Our ref: DOC21/1127971-3

Your ref: SSD-6464 MOD 2

Mount Thorley – Warkworth Coal Mine - Lemington Underground Mine Water Storage Project (SSD-6464 MOD 2) – Review of Response to Submissions Report

BCD have reviewed the Response to Submissions Report in relation to BCD's advice on biodiversity and the flood risk assessment in our letter dated 18 October 2021.

Figure 3A: General Development Layout – Lemington Underground Mine Workings

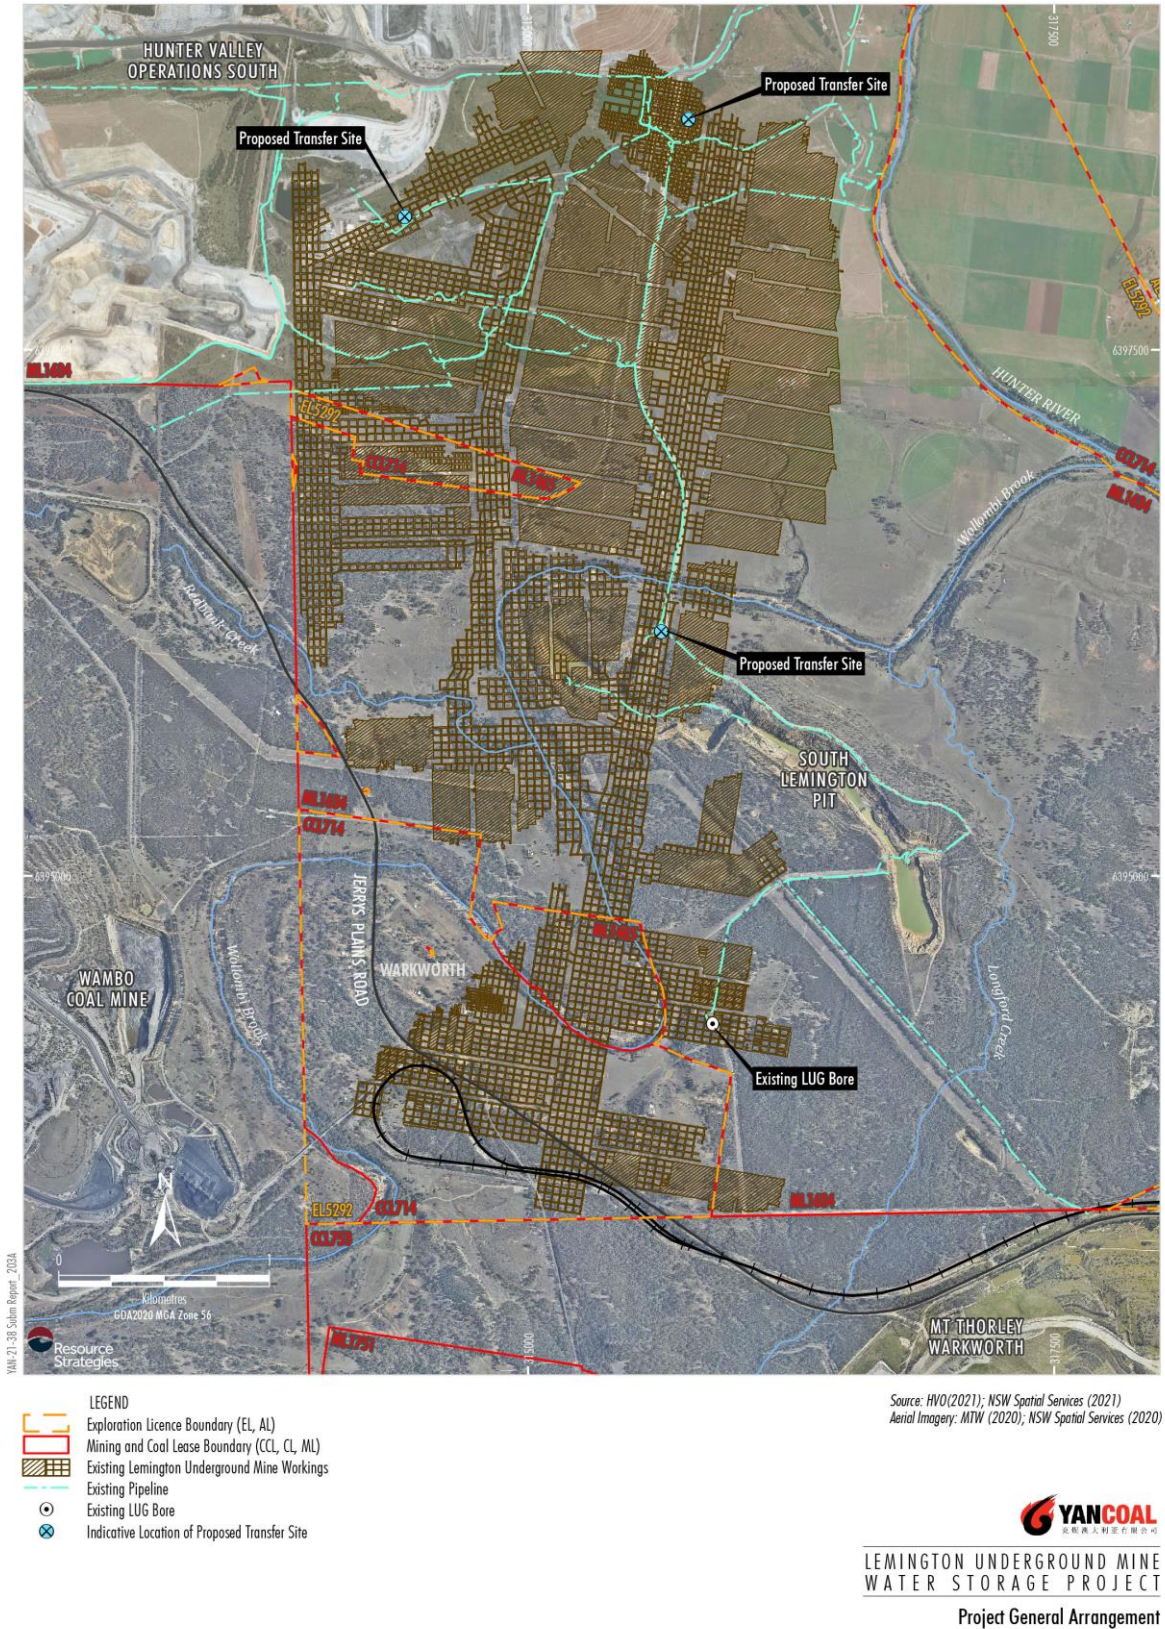
A report has been provided from SCT Operations Pty Ltd assessing the impacts of wetting and drying cycles on bord and pillar stability. It has been identified that only a small section of the Lemington mine, 20 Ha in the north western section has pillars of small size which may be impacted by the intended use as a water storage. Subsidence is a risk in this area however it affects mine infrastructure only.

The impacted area does not extend beneath the Hunter River, Redbank Creek or Wollombi Brook and the report indicates that no impact on these water courses is expected.

No further assessment of the impacts of wetting and drying are required. The proponent will need to review impacts on mine infrastructure if subsidence in the north western section causes changes to mine dams or haul roads.
